From: Simon Davis
Sent: 26 April 2019 11:03
To: Chris Sprules
Subject: RE: ** FP/42/19/DOC - CYCLE ROUTE**

From: Chris Sprules
Sent: 25 April 2019 11:10
To: Simon Davis
Subject: ** FP/42/19/DOC - CYCLE ROUTE**

FP/42/19/DOC Hampshire Houses Stanhorn Grove Felpham

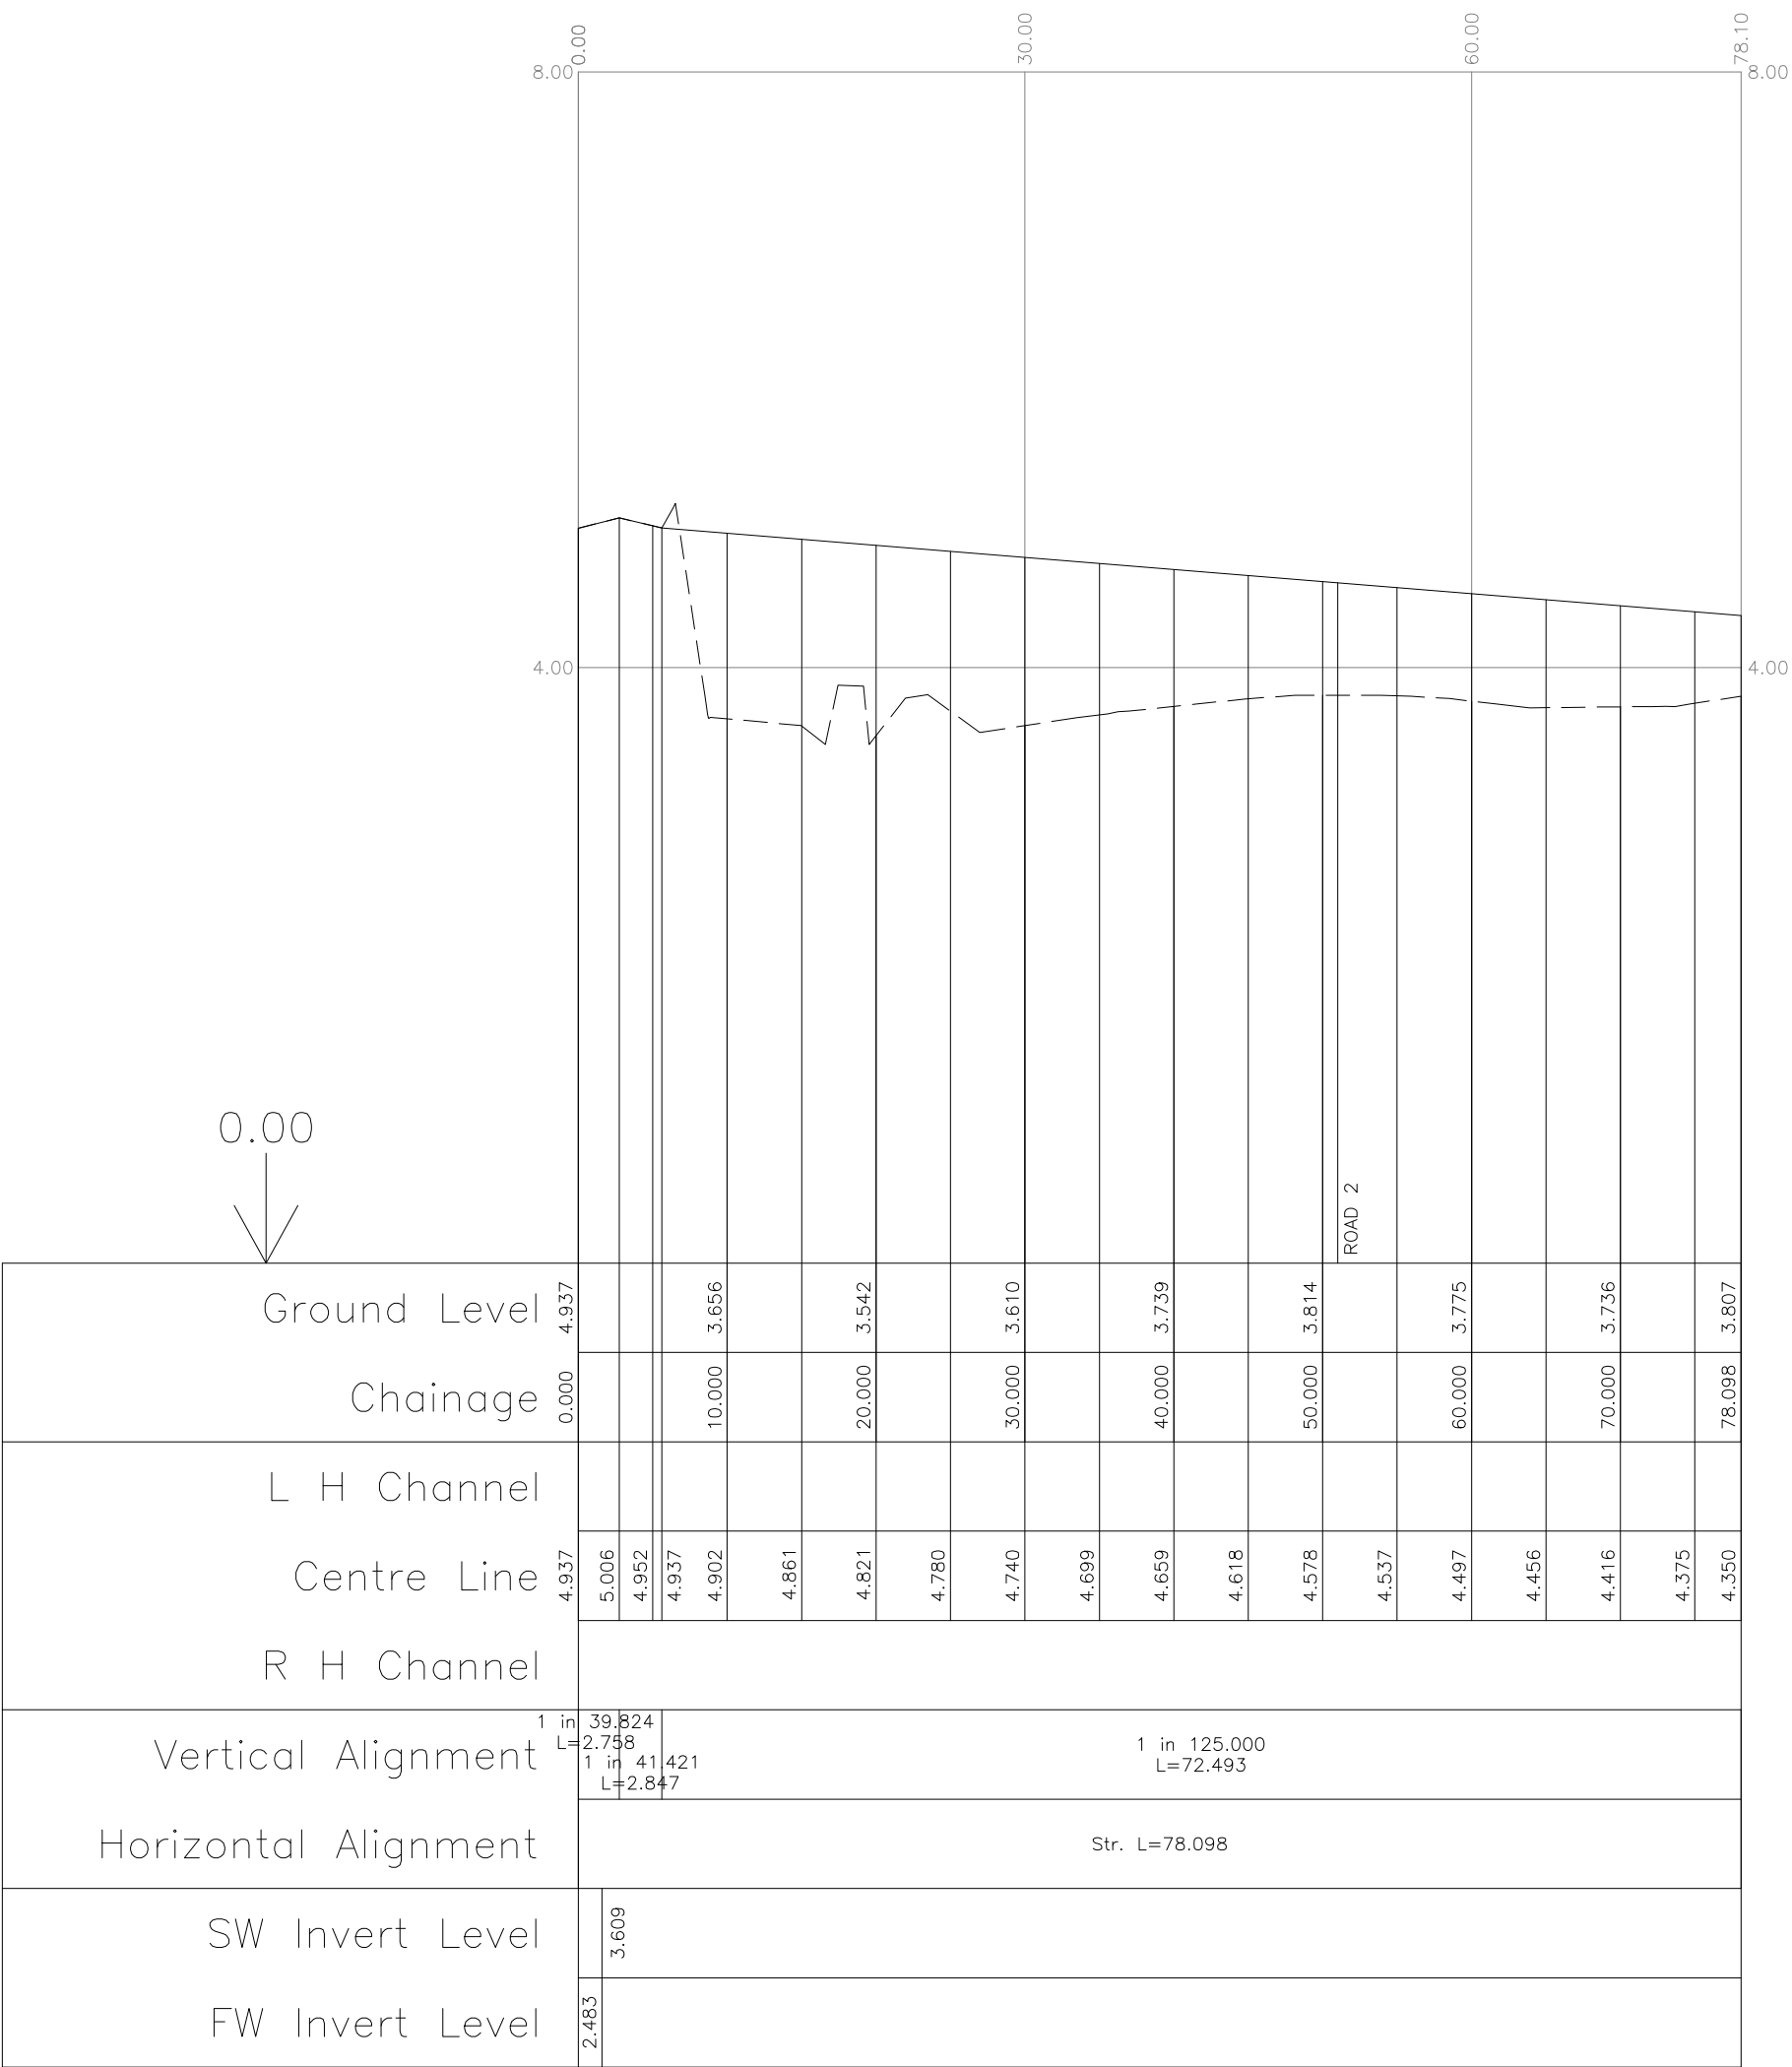
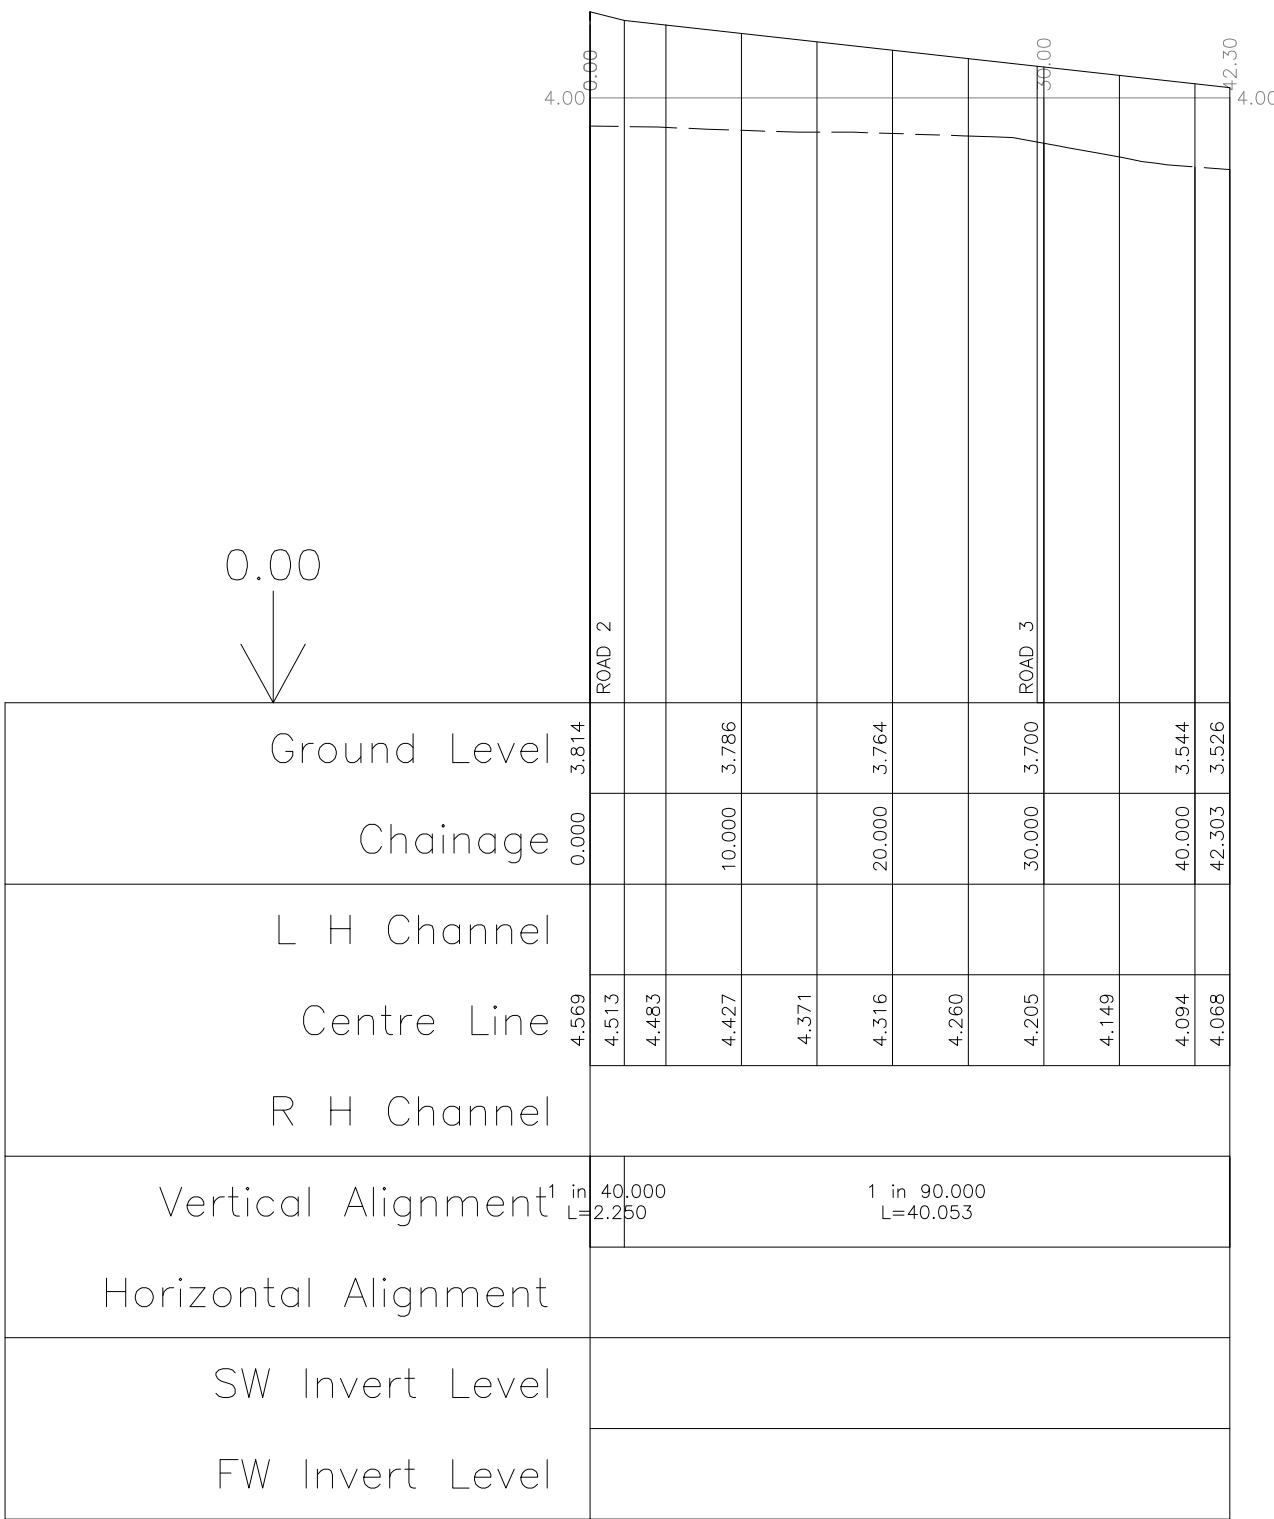
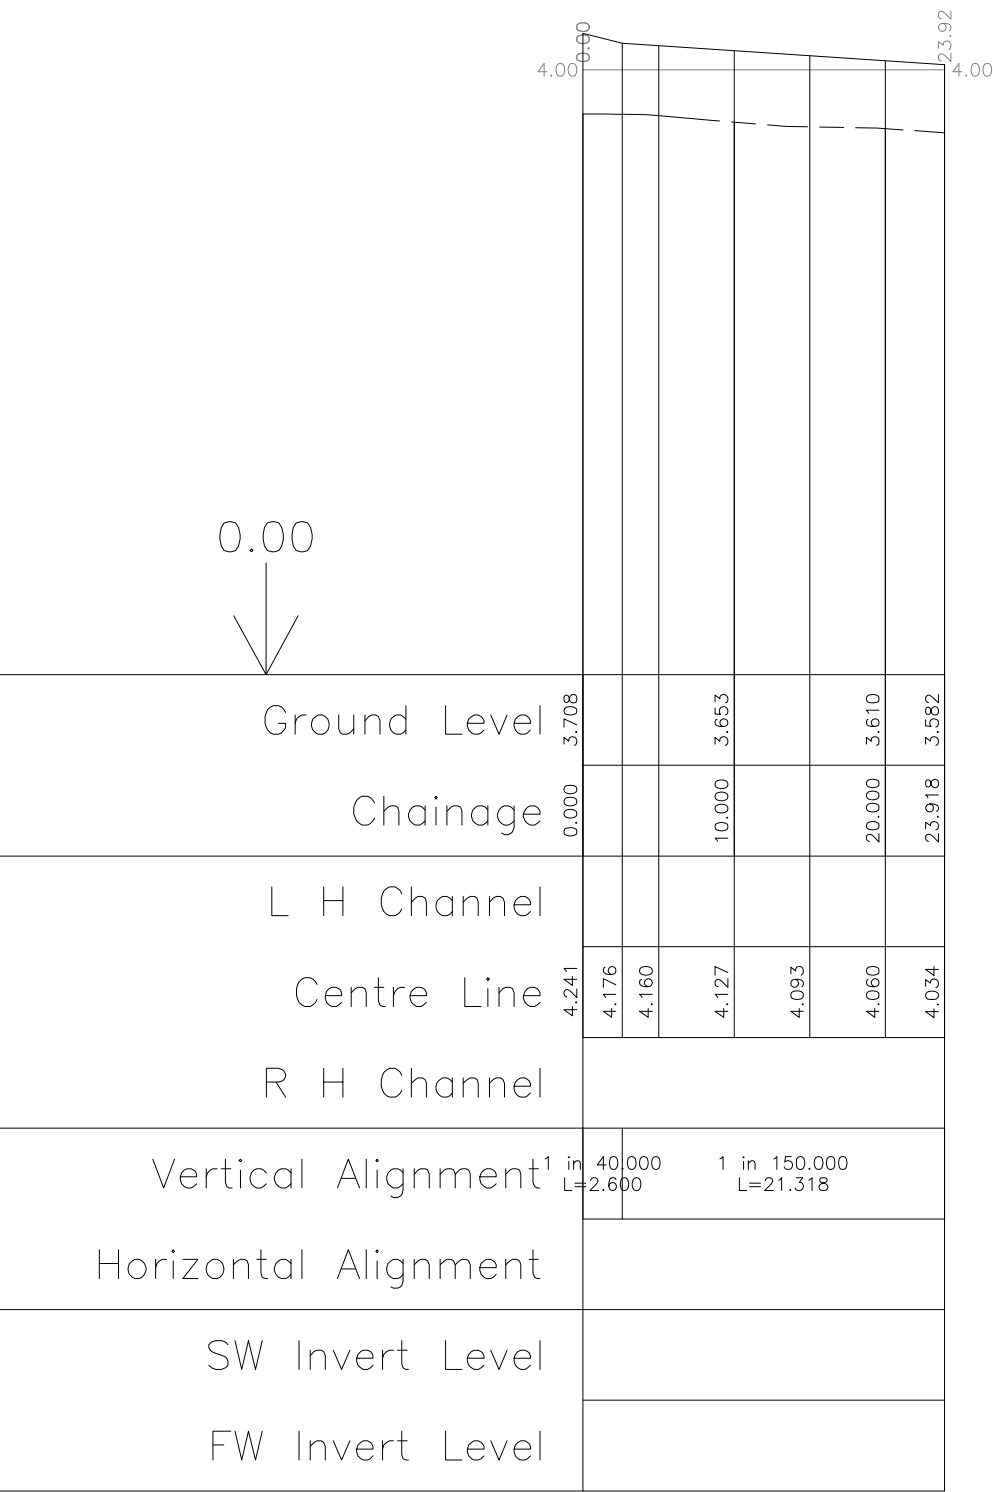
The access road to site appears to be about 3-4 foot higher than the cycle route it crosses (which has only recently been completed). Are you aware of this? And can you confirm why they needed to design it so that it would cause such a major impact on anybody trying to cycle along it?

We were aware of there being a levels change (please see attached levels plan extract showing existing levels in feint and new levels underlined). The levels change was required due to the raising of levels on the site as a result of drainage concerns. I would consider that the raising of the access will ensure that there is no safety concerns to cyclists as they will need to stop and dismount to walk up to and cross the access road.
